**SOIL, GEOLOGY, GEOLOGIC HAZARD,  
AND WASTEWATER STUDY,  
SADDLEHORN RANCH SUBDIVISION  
EL PASO COUNTY, COLORADO**

**William Guman and Associates, LTD**  
731 North Weber Street, Suite 100  
Colorado Springs, Colorado 80903

April 29, 2019

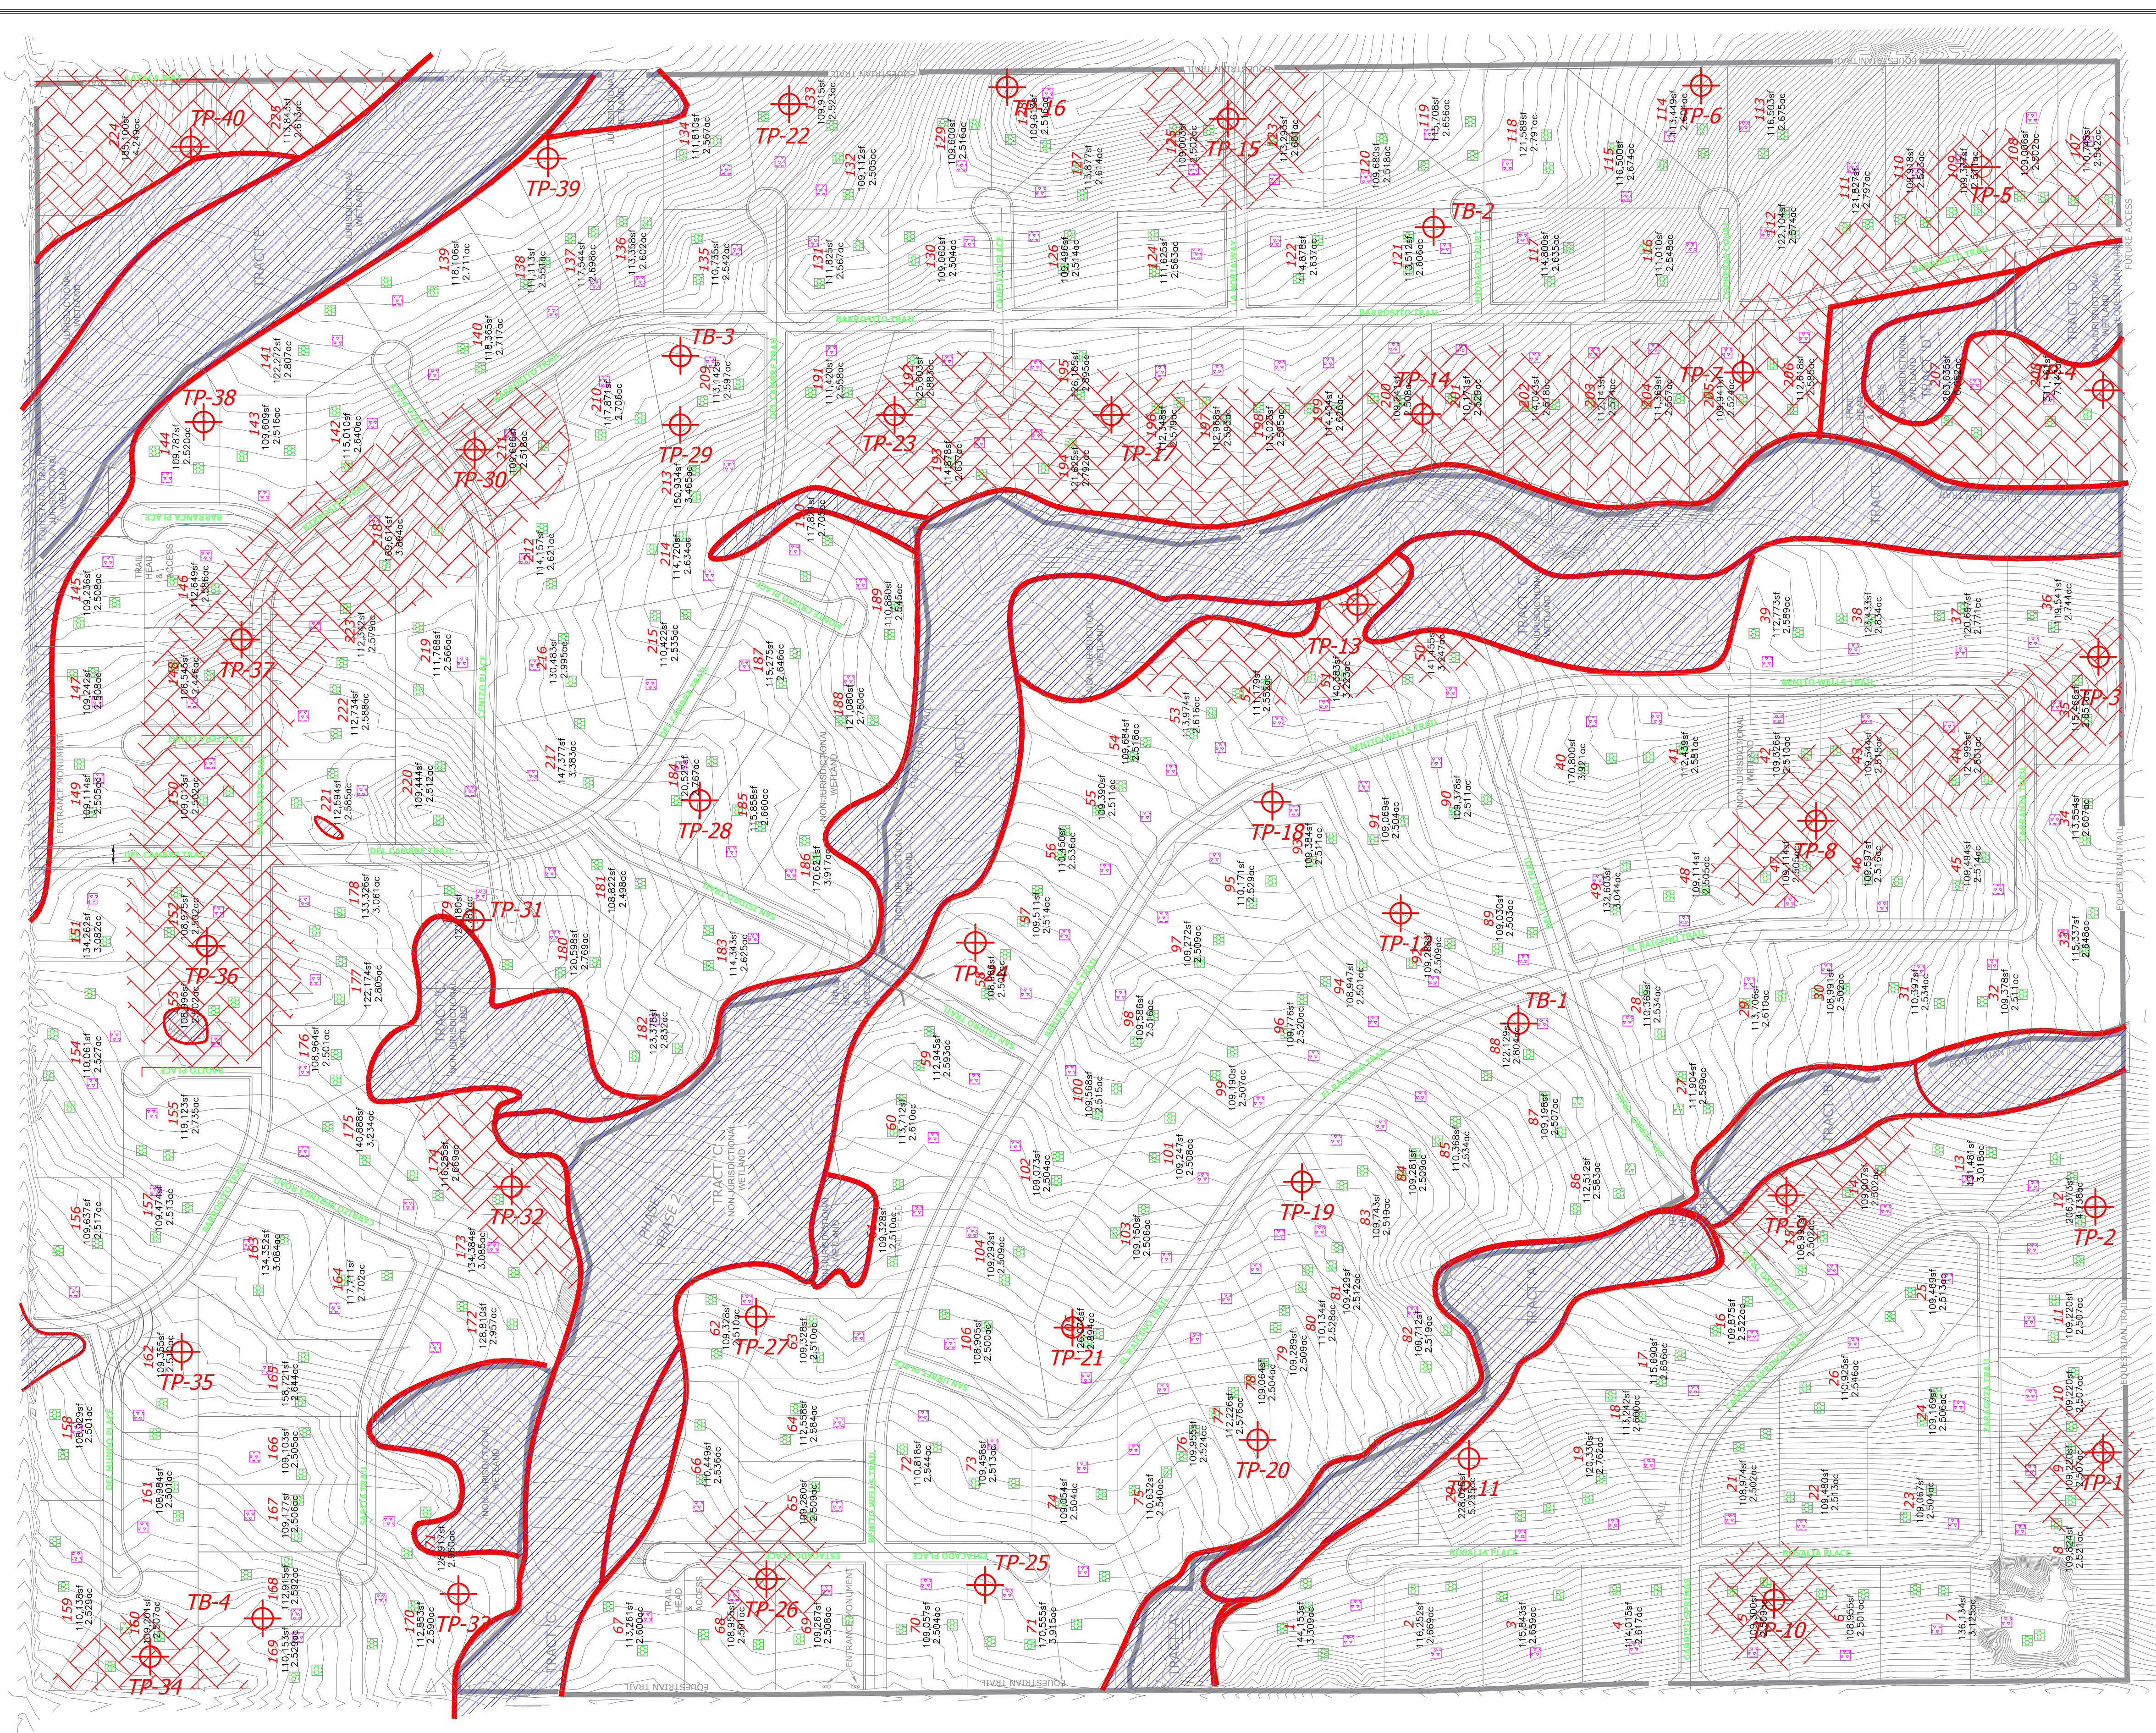
Regulations regarding  
OWTS report have changed  
since this report was  
prepared. Please review  
LDC Sec. 8.4.8 and make  
the appropriate changes.  
This is the same report that  
was submitted as the soils &  
geology report.

This should be a site specific  
report for Filing 2.
